Subject: Comments on Planning Application K14/15/HH (Broadbeach, 39 Coastal Road, East Preston, BN16 1SN)

We live at 41 Coastal Road, which is next door to 39 Coastal Road on the west side of the property. We wish to strongly object to this application for the following reasons:

1419 SK01A
Broad Beach 1:100
Proposed Ground Floor Plan
January 2015

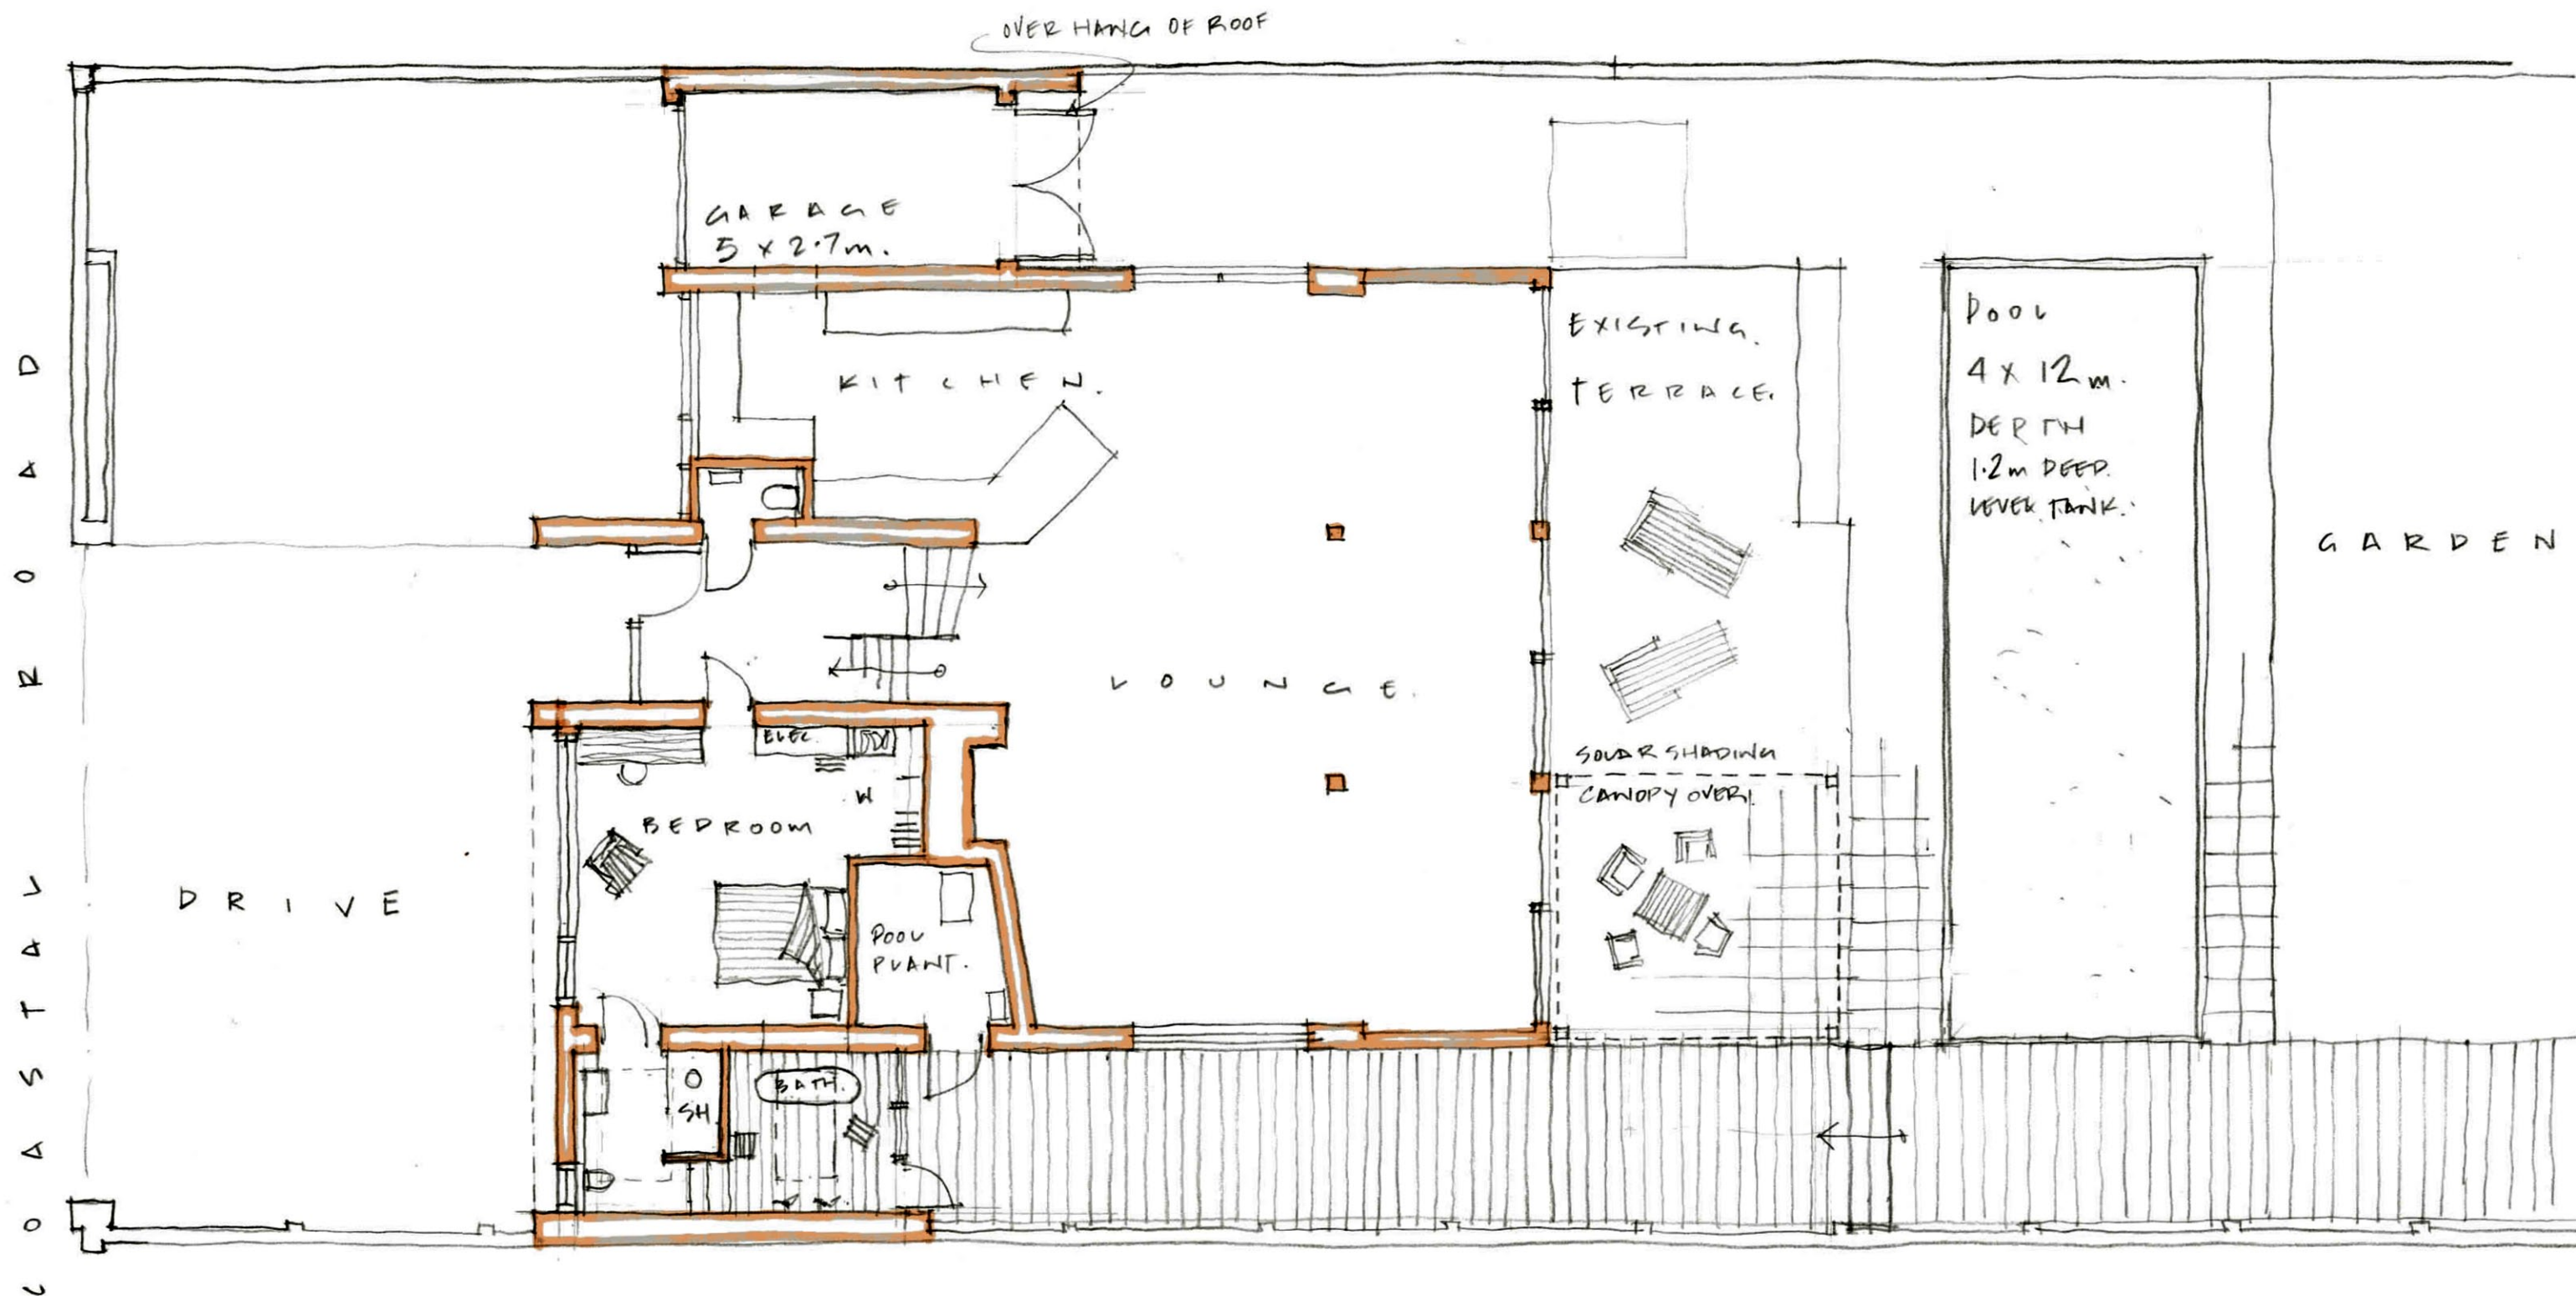
4. There appears to be the intention to build a large structure at the back of the house together with a canopy which would extend by approx 4 metres from the back of the south side of the house at a height of approx. 3 metres. If built, this would cut out light to our rear garden and sun room. This structure has not been included in the Design Statement but is clearly shown on the drawings for the proposed ground floor plan and south side elevation so we assume that there is an intention to build this.

5. There is also the likelihood of increased levels of ongoing noise from the property given the scale of the overall development being proposed especially as the intention is to convert a large part of the usable garden area into a 4x12 metre swimming pool with separate access to the rear garden and pool alongside our dividing wall. As the other doors to the rear of the property enter directly into the living room, we assume that this new access door, which opens directly onto our dividing wall, would be the main access to the swimming pool. In addition, if the extended house were to be used for commercial holiday lets (which is a concern as the owners do not currently live at the property), this could result in excessive noise both from the house and around the pool.

Proposed West Elevation

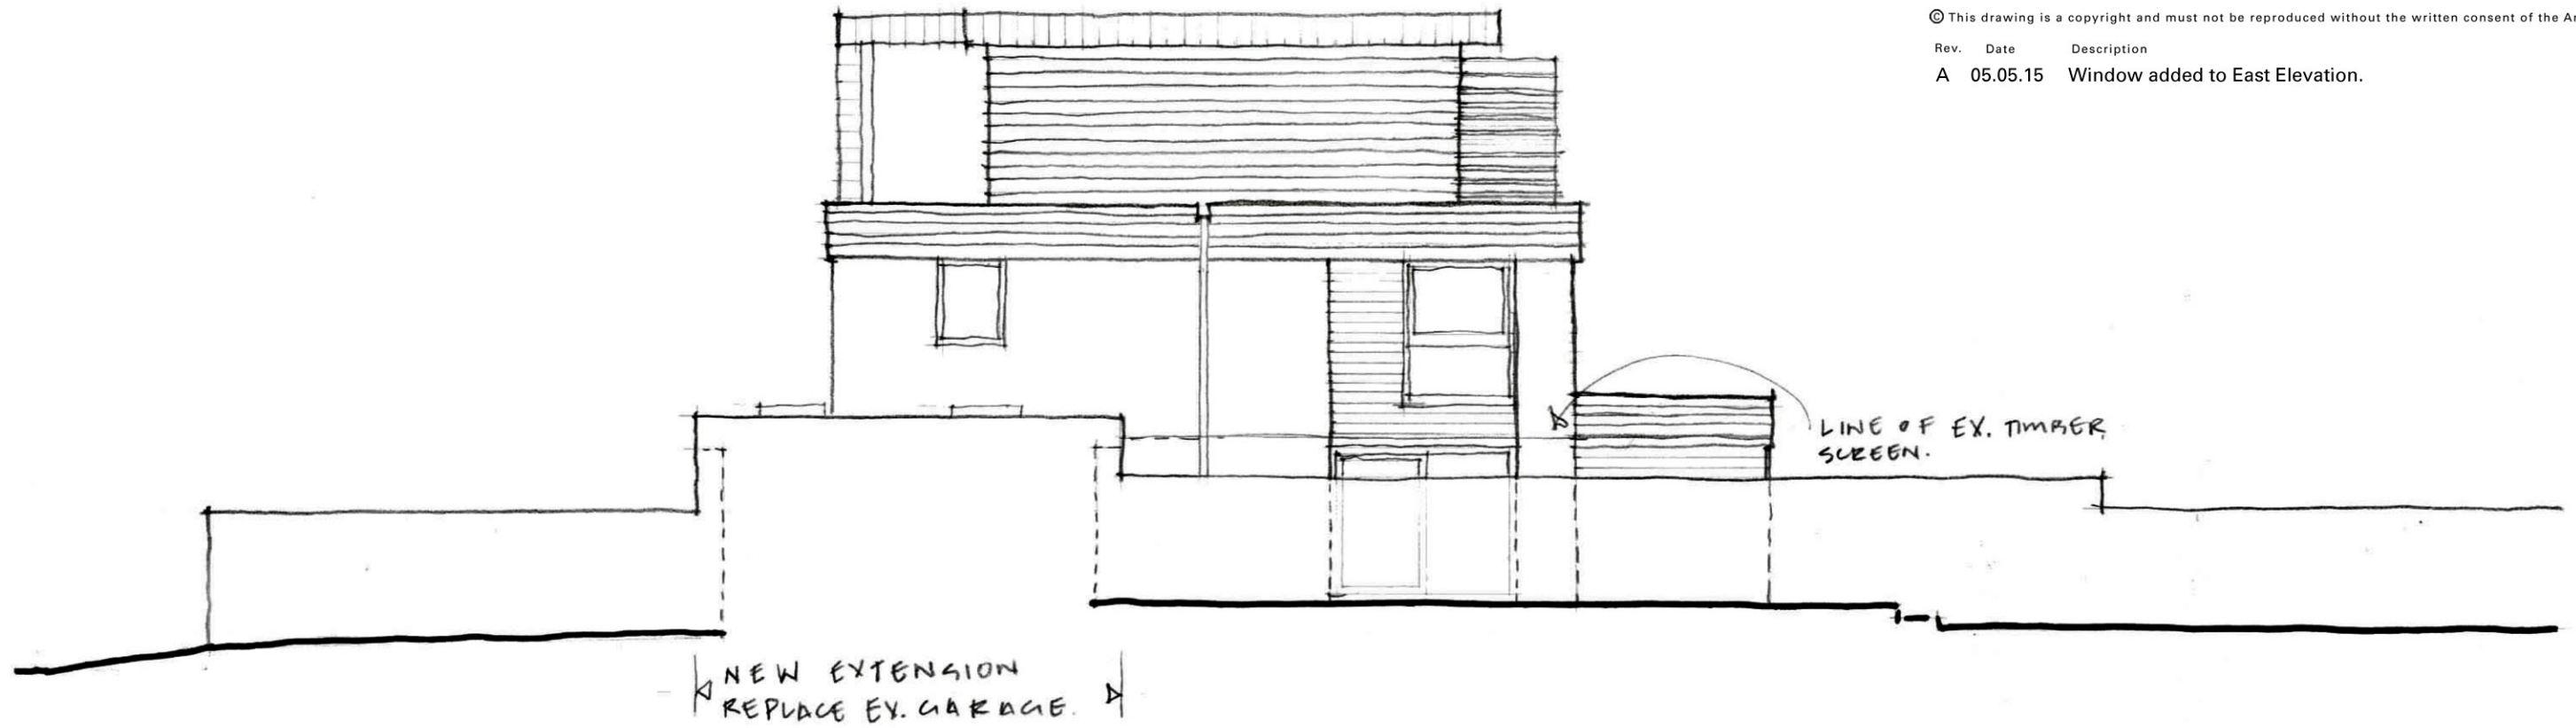
1. The proposed extension on the west side of 39 Coastal Road would detrimentally impact our property from the east side by placing a new flat roof extension directly adjacent to the dividing wall between our properties and protruding 1.5 metres above it, blocking light into our kitchen and affecting our privacy. Although Section 2.2 of the Design Statement states that the new flat roof would be a "similar height as the existing lean-to garage", the sketch of the proposed North elevation shows that this new flat roof would be 3.55 metres above the ground level of 39 Coastal Road. As the dividing wall on our side is 2.05 metres high, this will result in a protrusion of 1.5 metres above the wall on our side, which is not a "similar height". We are also concerned that, as the "lean to garage" does not appear to be a permanent structure (it is actually a filled-in carport), building work on the west side could require foundations to be dug on our boundary which could destabilise the dividing wall and cause damage to our property.

2. There would be increased noise levels as a result of having living accommodation directly on top of our property as there would be no gap between the west side extension and our property, and there would be a door from this extension opening directly against our dividing wall. The "lean-to garage" which would be demolished to create space for this new extension is not accessible from either the main house or its integral garage. This currently adjoins our dividing wall, however it does not exceed the height of the wall whereas, as noted above, the proposed development would be 1.5 metres above the wall.

Proposed Second Floor Plan

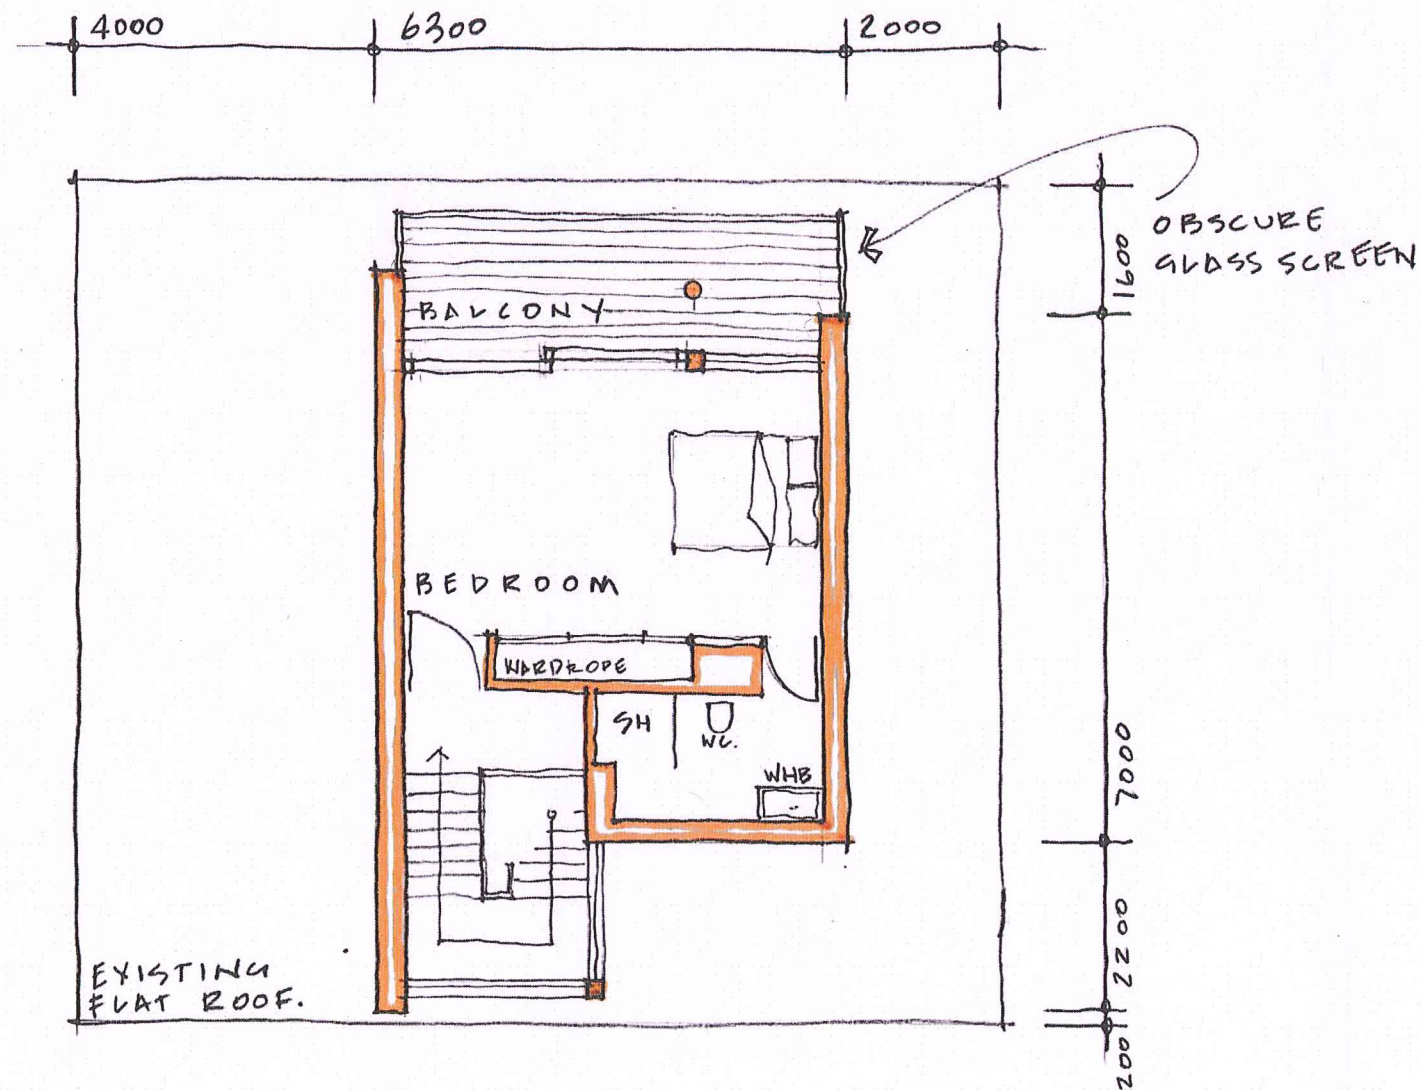
3. The proposal to create a 3rd storey would result in our property being further overlooked and impact our privacy. Part of the interior of our house is already overlooked from the south-facing windows of 39 Coastal Road. The proposed additional south-facing windows on the new 3rd storey would mean that we would then be further overlooked from a higher vantage point.
